RMS Ref: SYD11/00779/03

Your Ref: MP05_0157

BUILDING & CONSTRUCTION WASTE RECYCLING FACILITY, MOOREBANK (05_0157)

Reference is made to the Department of Planning and Infrastructure's correspondence dated 2 October 2013 with regard to the Preferred Project Report (PPR) for the building and construction of Moorebank waste recycling facility, which was referred to Roads and Maritime Services (RMS) for comment.

4 ATTACHMENT B – PROPOSED BRICKMAKERS DRIVE INTERSECTION

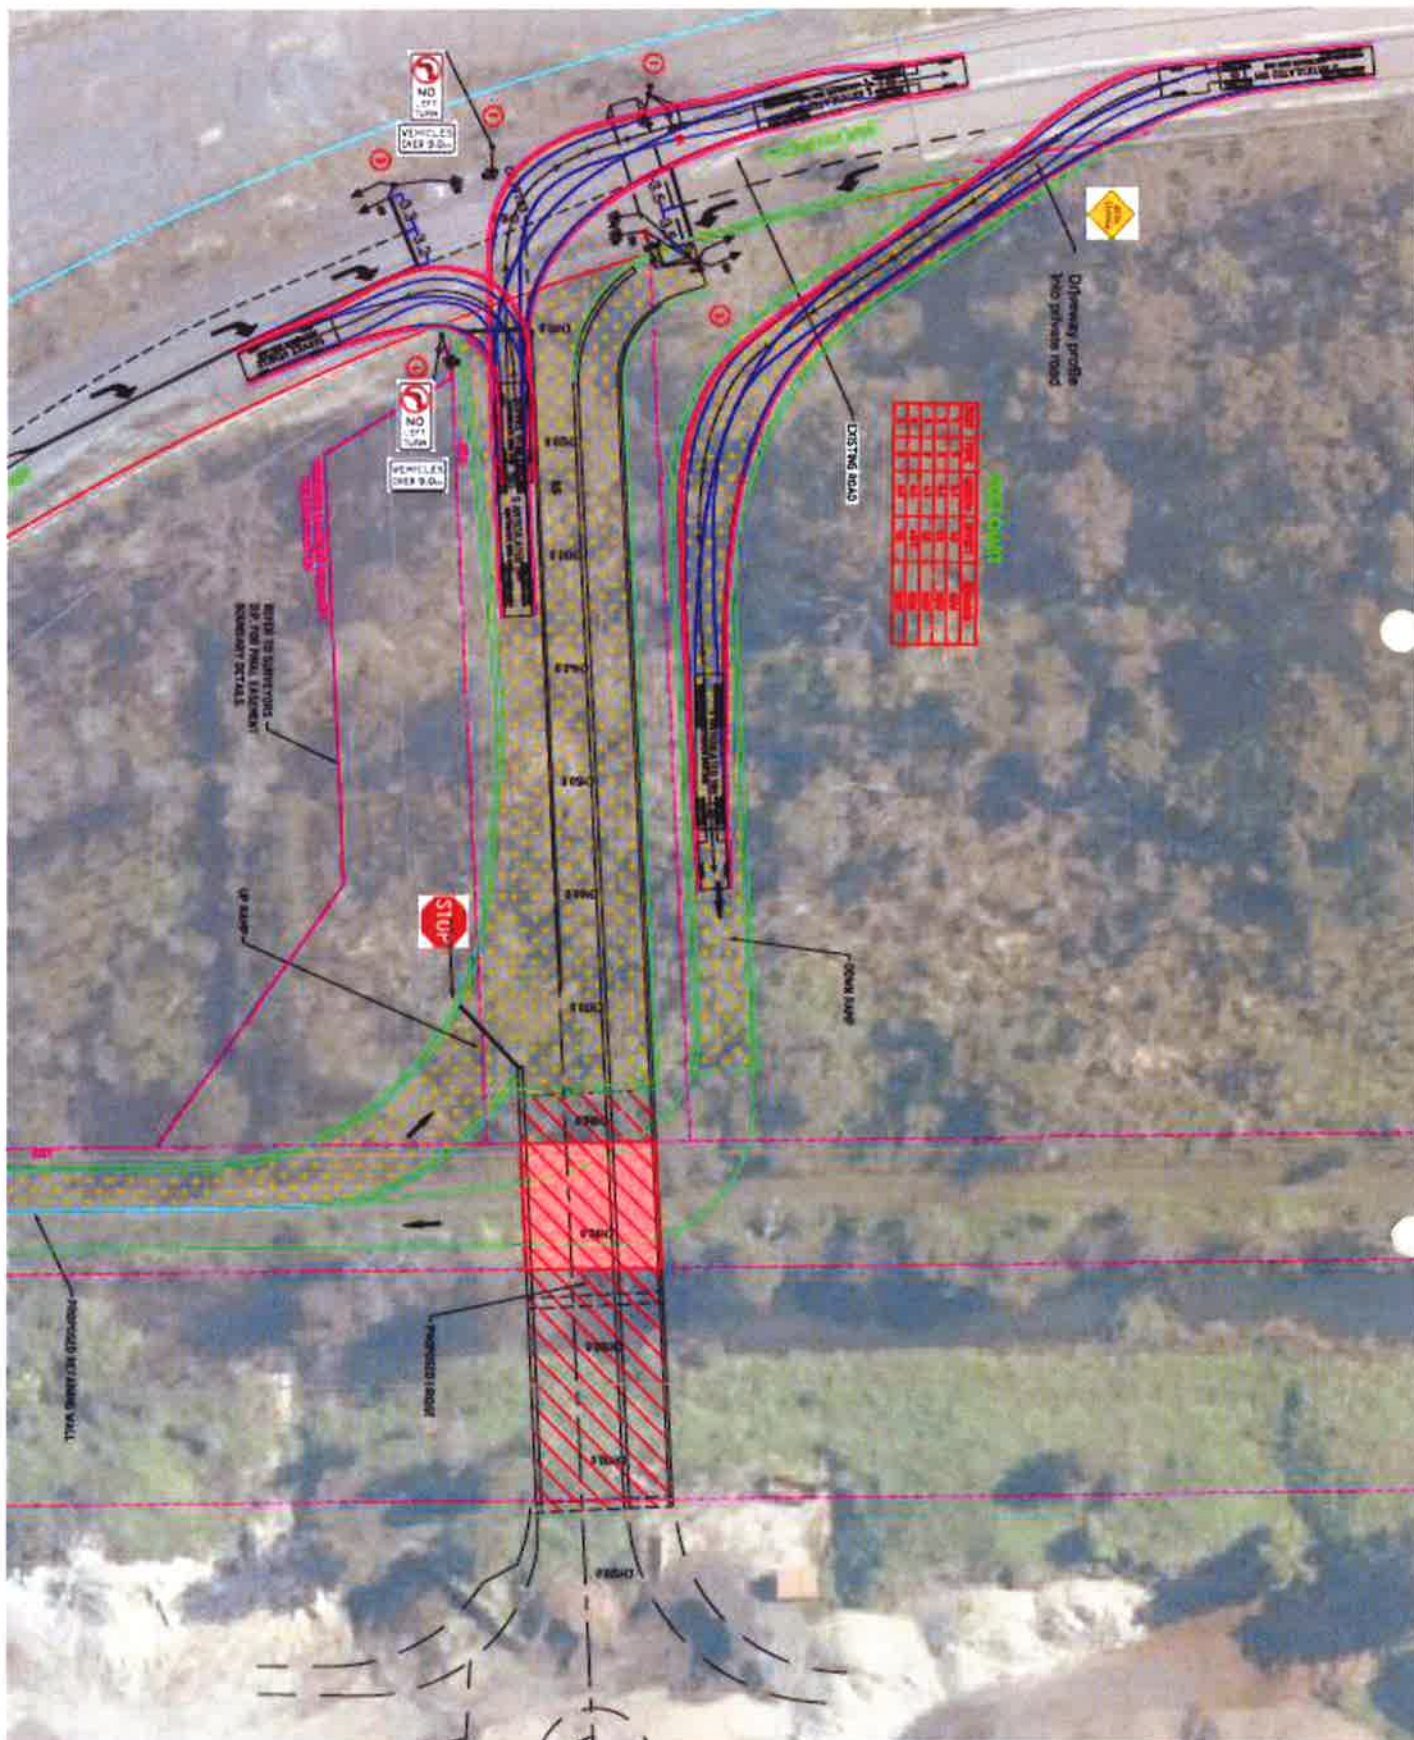
7. The proposed intersection on Brickmakers Drive as shown on the figure 2-7 of the report should be submitted to Council for approval. All the signage and line marking on Brickmakers Drive should be referred to Council's Local Traffic Committee for consideration.
8. The proposed ramps off Brickmakers Drive shall be fully operating prior to the release of the Construction Certificate for the proposed materials waste recycling facility.
9. RMS does not support the use of convex mirrors.
